Application no: 19/02550/F

Location: Land to the east of M40 and south of A4095, Chesterton, Bicester

Lead Local Flood Authority

Objection

Figure 3-5: Surface Water Discharge Route With Indicative Site Boundary

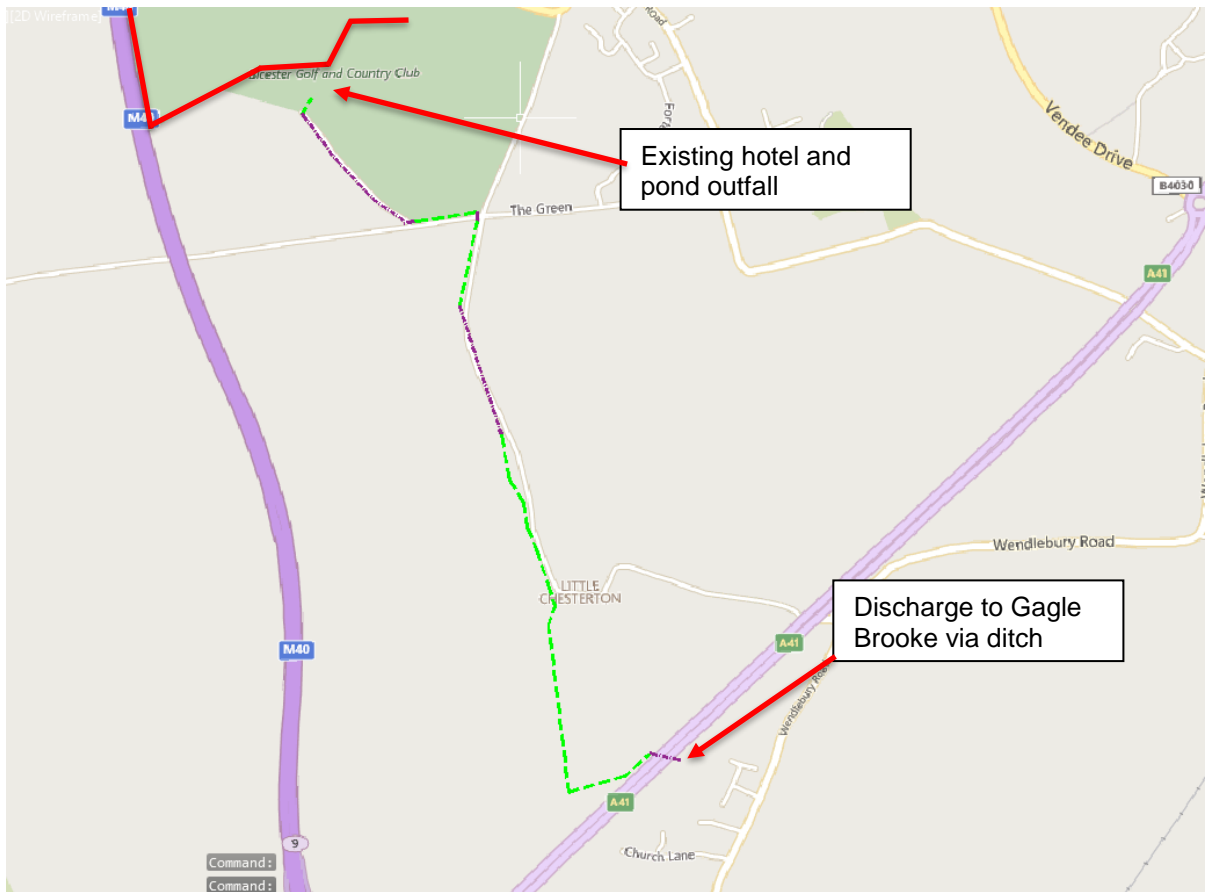
Discharge noted to be to Gagle Brook ordinary watercourse. Riparian ownership and consent to discharge to be justified. Ditch condition and capacity to take additional flows to be demonstrated.

Figure 3-6: UAV Groundwater Survey

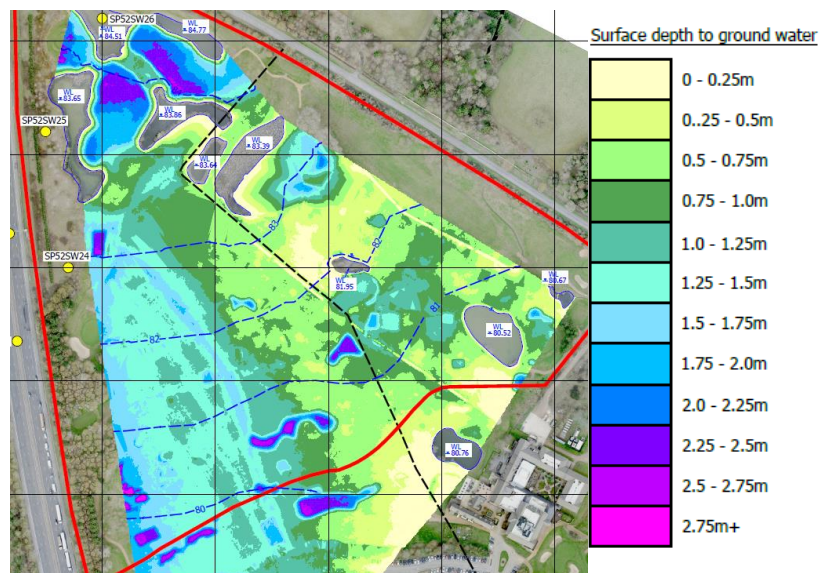
Borehole/BRE to determine level of ground water to be provided.

Ground water depth to bottom of proposed tanking/attenuation requires justification as does the need for buried attenuation when it appears there is ample space to use on the surface SuDS and surface water management techniques.

Figure 5-2: QBAR Calculations

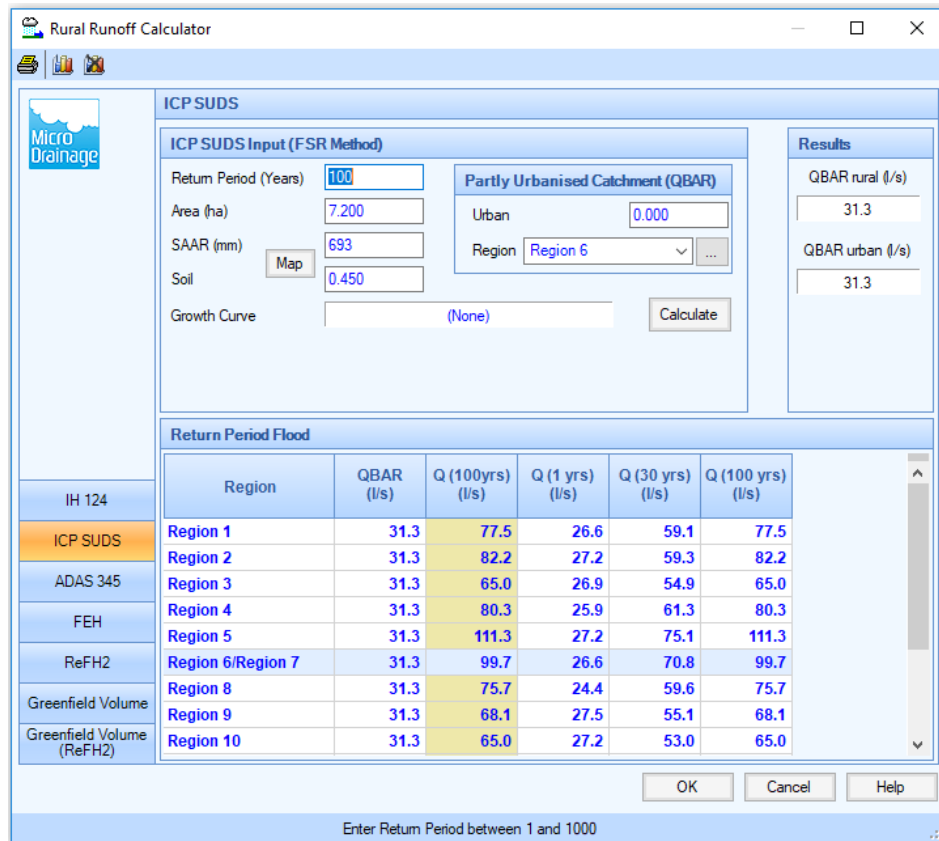
Section 5.2.2. identifies the use of Qbar methodology. For a site this size FEH should be used, (Qmed).

**Figure 5-1: QBar Calculation**

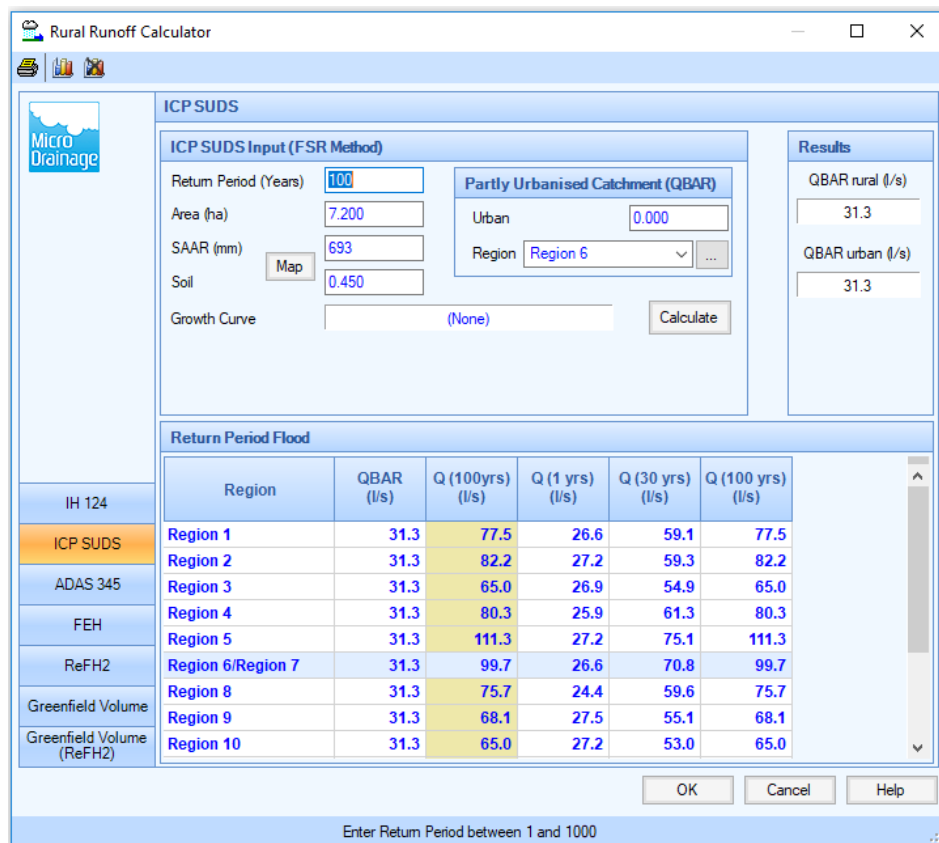
Flow control from site should ensure greenfield discharge for relevant return periods, i.e. 1:10, 1:30, 1:100 and 1:100 + 40% climate change. It is doubtful the current proposed attenuation approach will maximise the attenuation and simply allow free discharge up to the 1:100 + 40%.
